**Consultation Response from KC,
Highways Development Management**

2024/90273 adj, 53, Garden Place, Dewsbury Moor, Dewsbury, WF13 4EP

Erection of two semi detached dwellings

Date Responded:6-1-2025.

DRAWING TITLE
Site Block Plan
REV 01

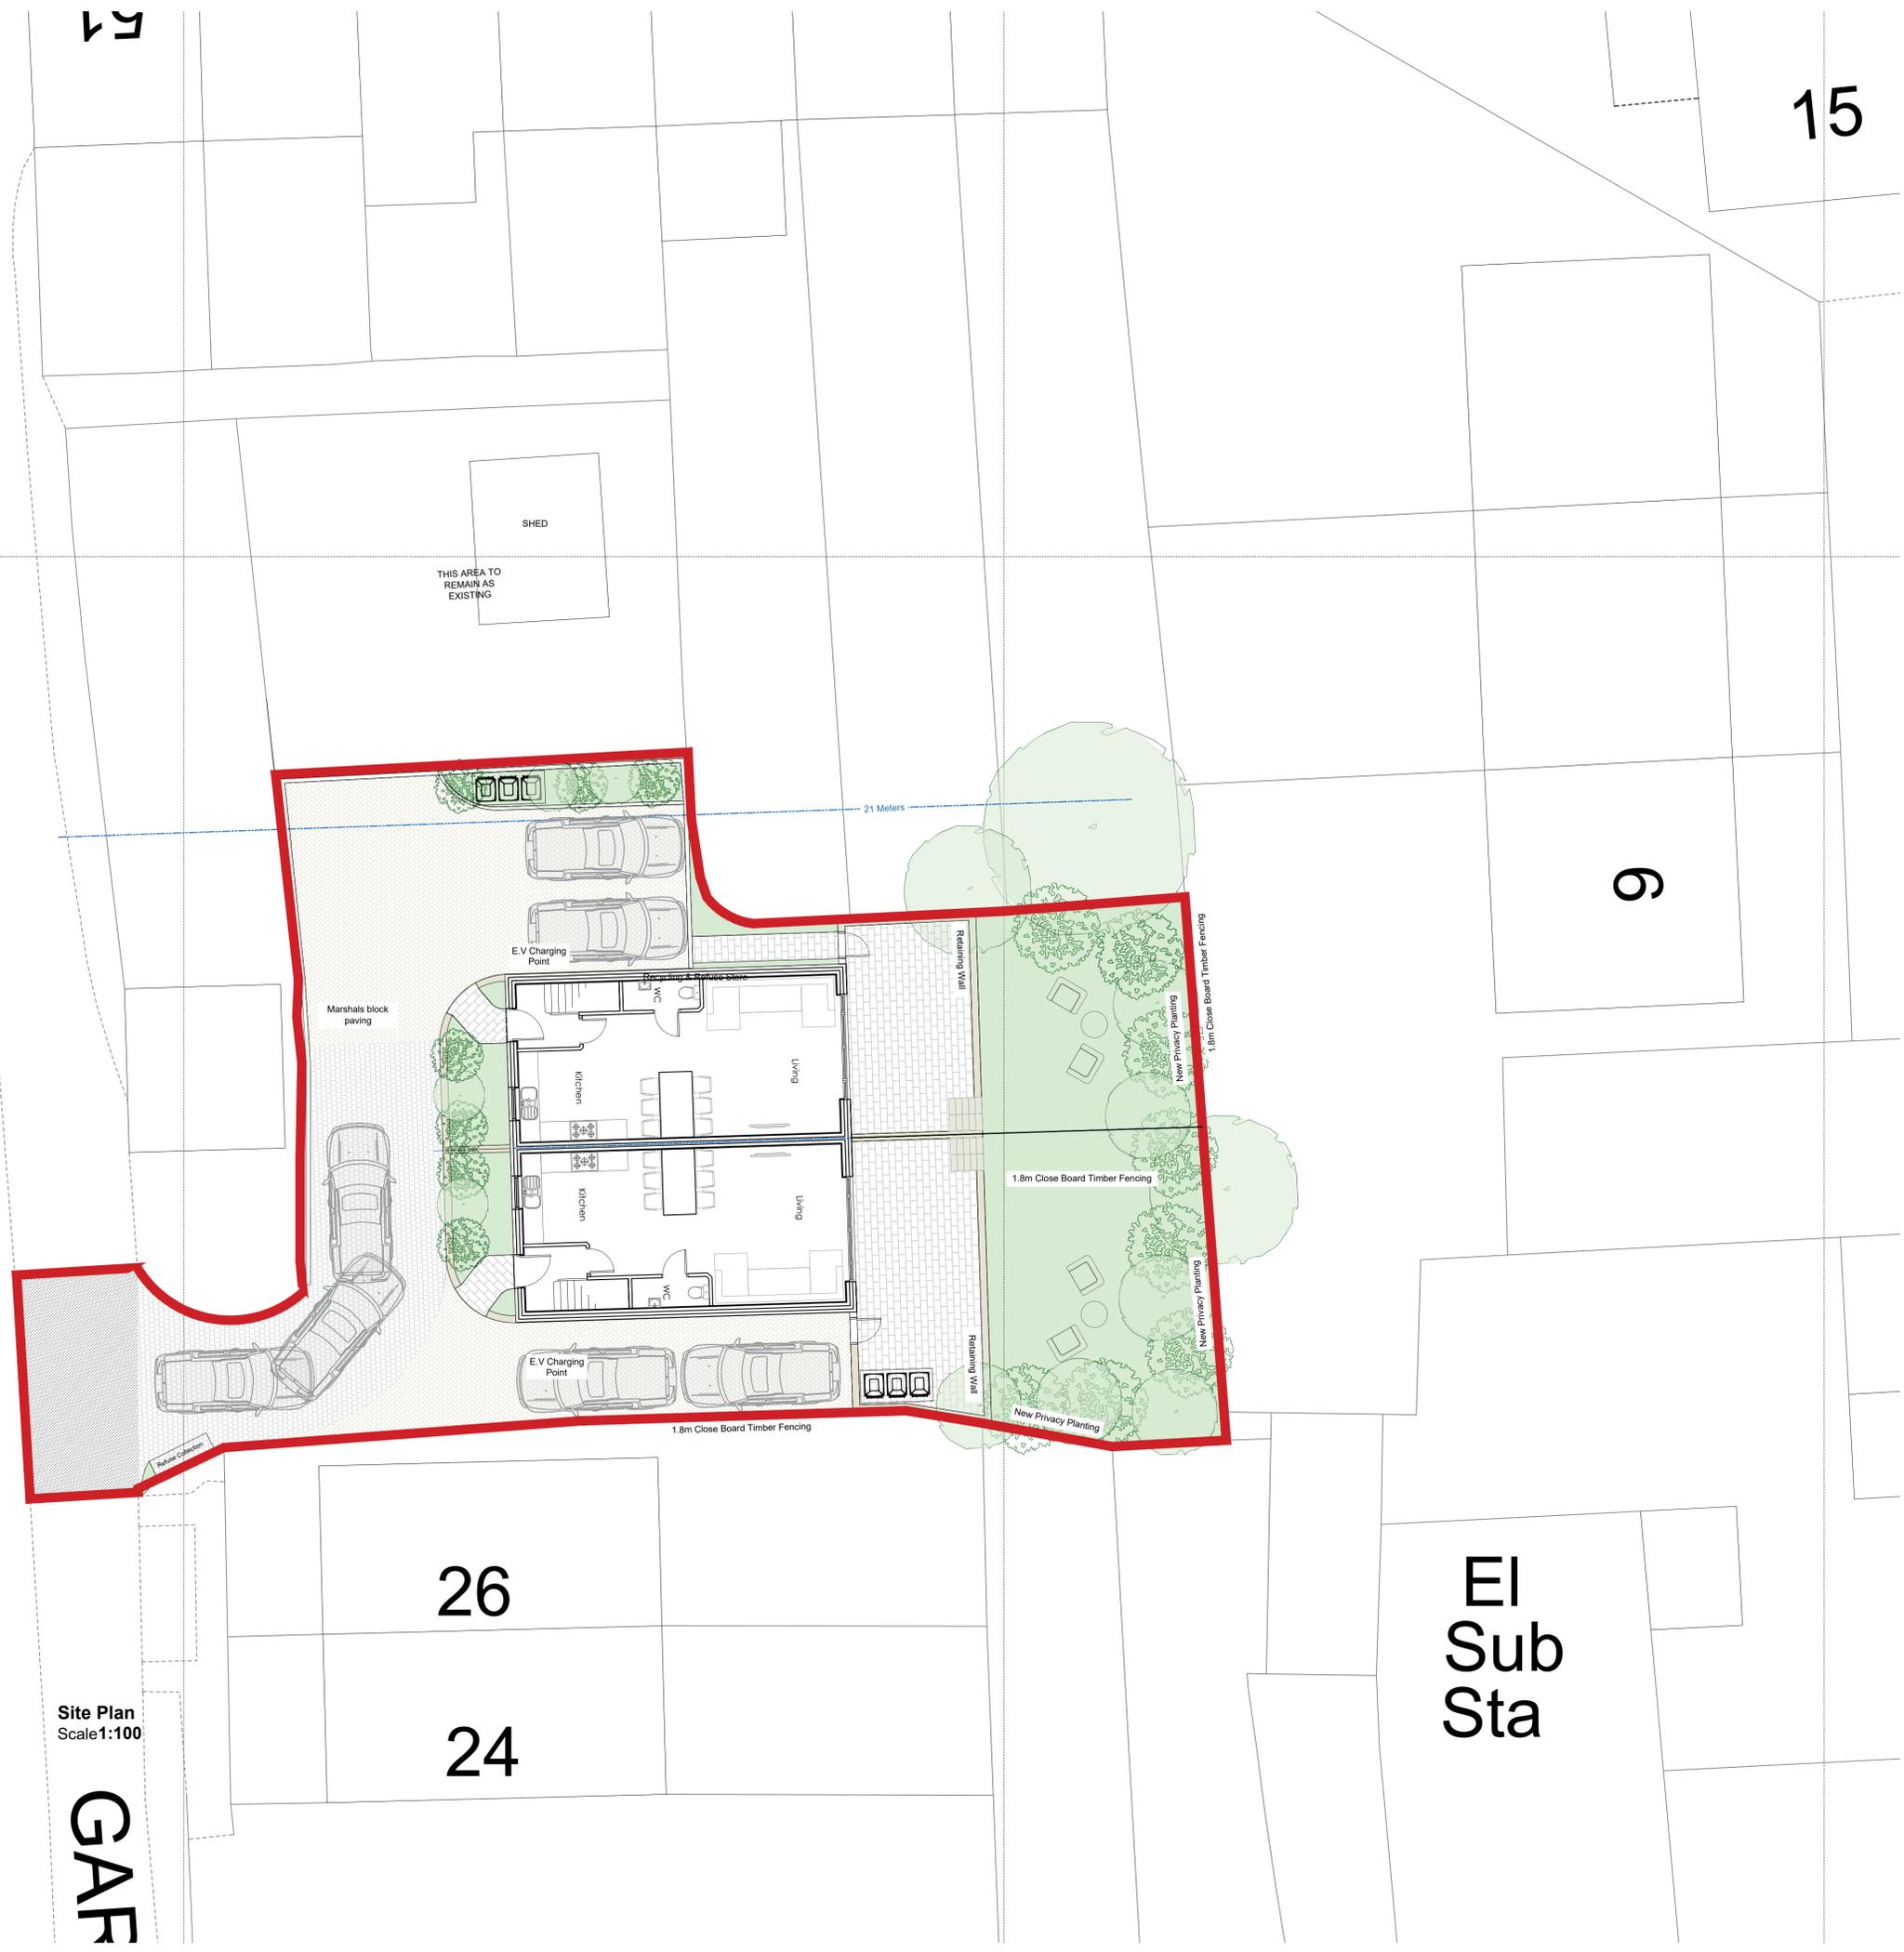
The access between Church Lane and the site access should however be shown to be widened to 4m as required by condition 4 of the 2022 application.

The widening to the access (Garden Place) is not shown and these proposals can not therefore be considered acceptable.
